**ADC Planning Consultation
Response from the Historic Buildings Adviser**

Application Number	A/3/14/L & A/2/14
Address	Angmering Manor, Angmering
Description	Construction of building to provide 5 additional bedrooms.
Case Officer	Anita Gardner
Site Visit	Previous

Title
ADDITIONAL GARDEN BEDROOMS
ELEVATIONS

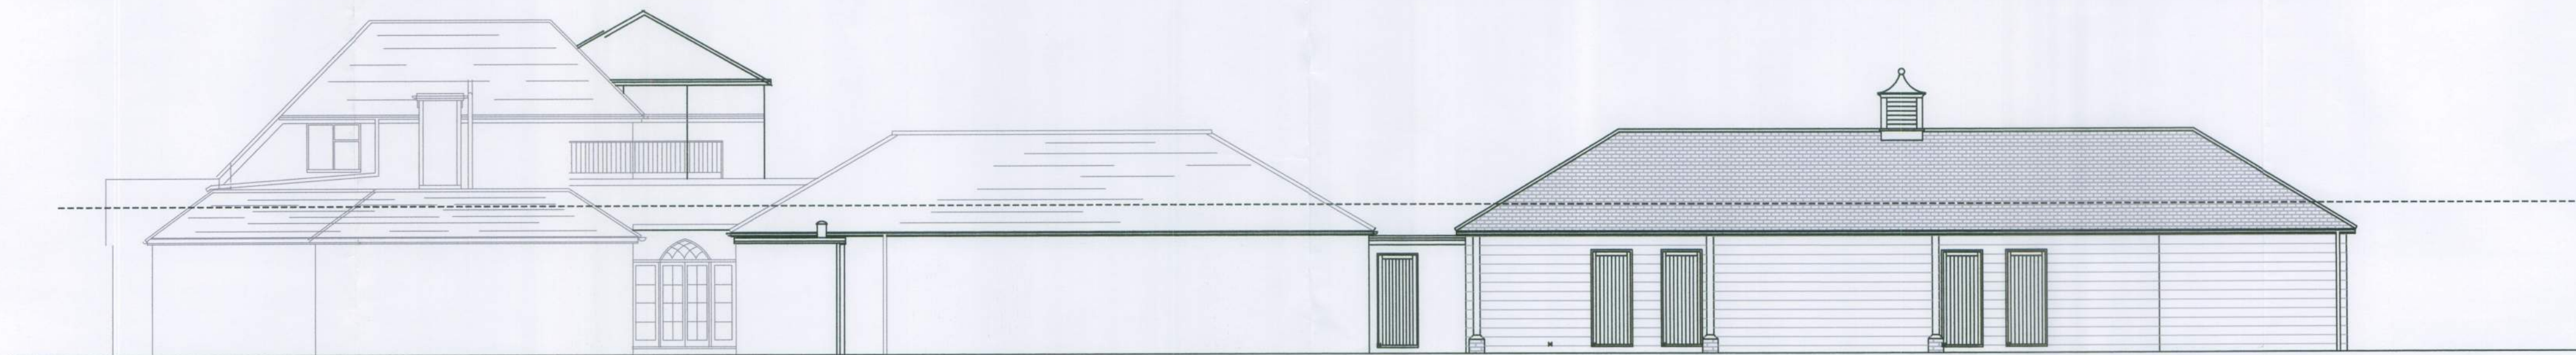
Whilst the location and scale of the building is generally acceptable, there remain reservations with its design. Of particular concern is the use of Georgian, arch windows which appear at odds with the half hip roof and are not particularly convincing on an outbuilding. We would recommend that the 'arched' element is removed.

A further improvement could be the use of a full hip roof with deeper eaves to create a more simple and elegant roof form, particularly given the depth of the building.

Title
ADDITIONAL GARDEN BEDROOMS
ELEVATIONS

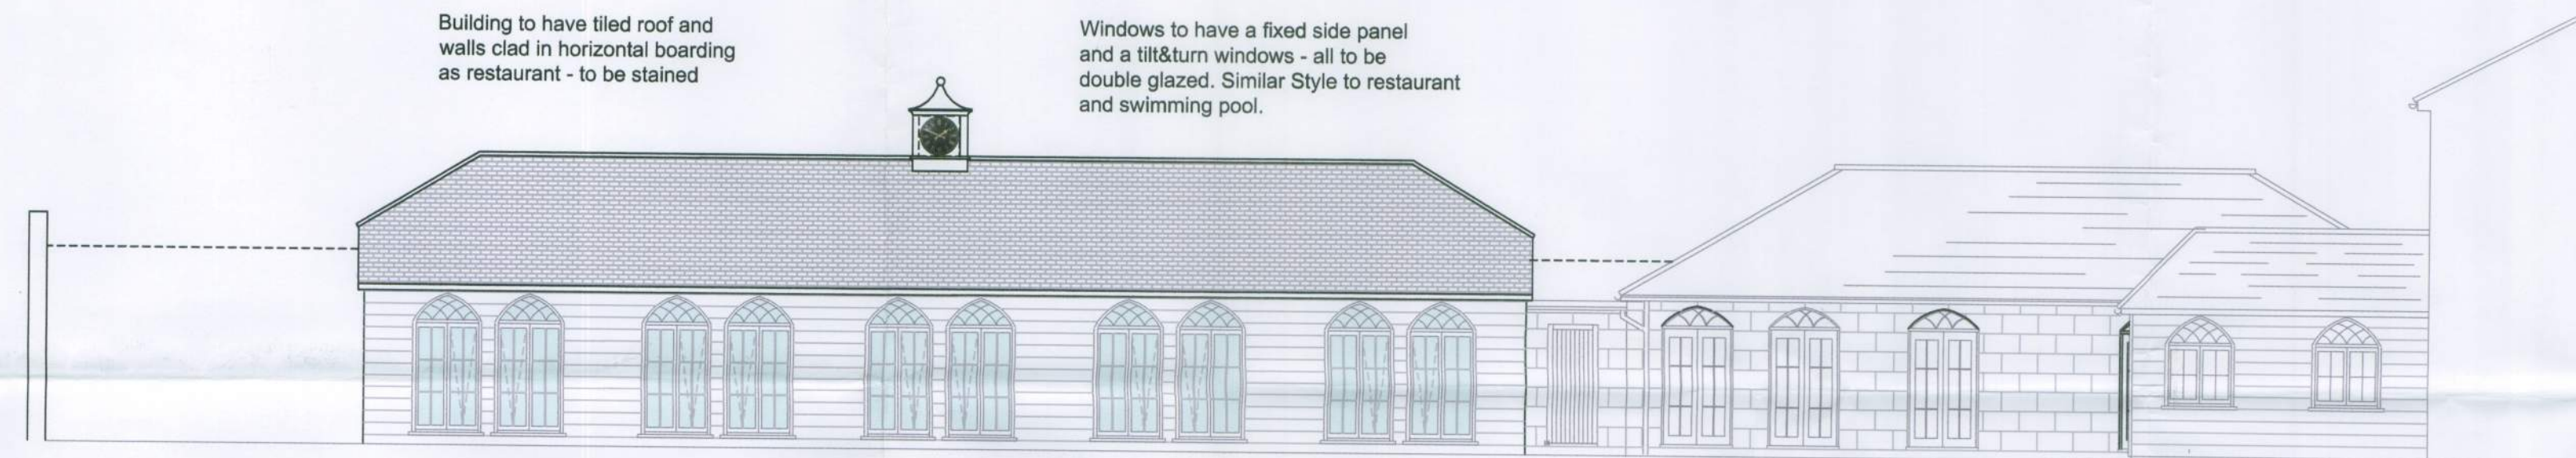
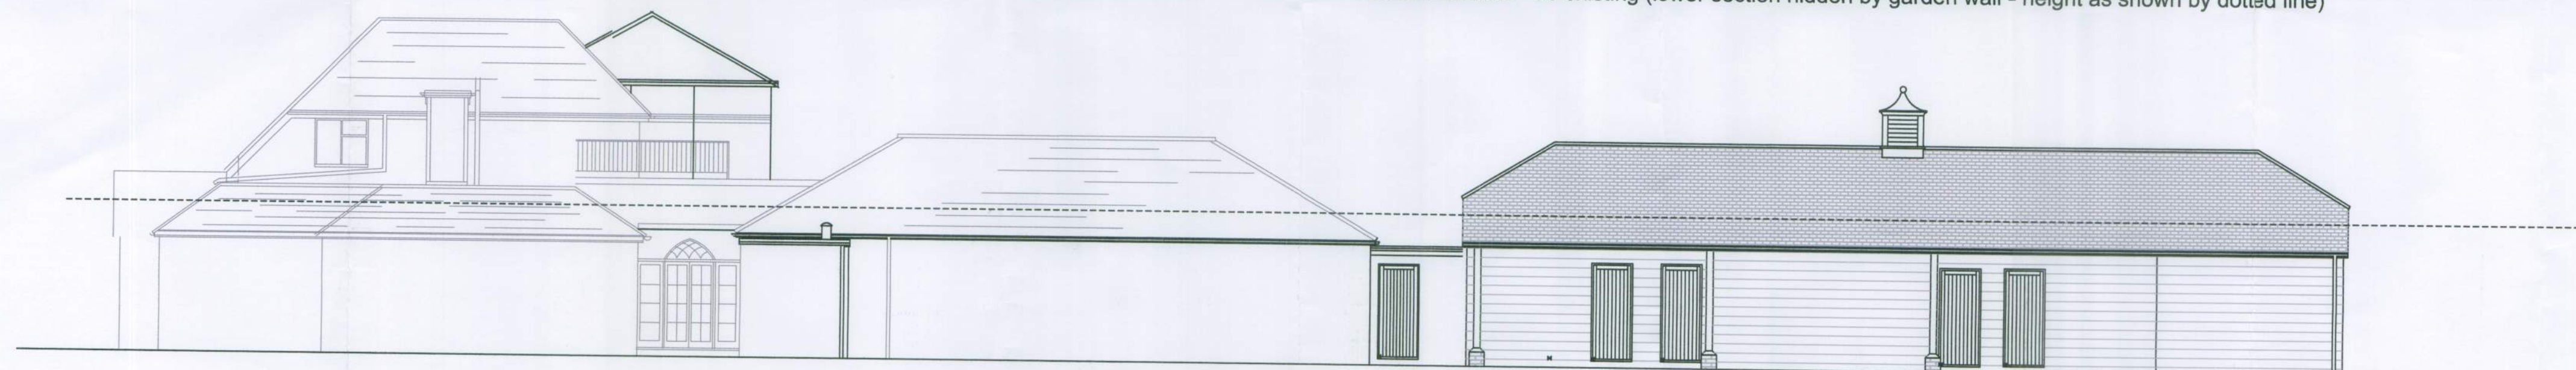
- Door details including sections
- Material samples for roof and elevations
- Detailed drawing of clock tower (please note that this is not shown on the south elevation).
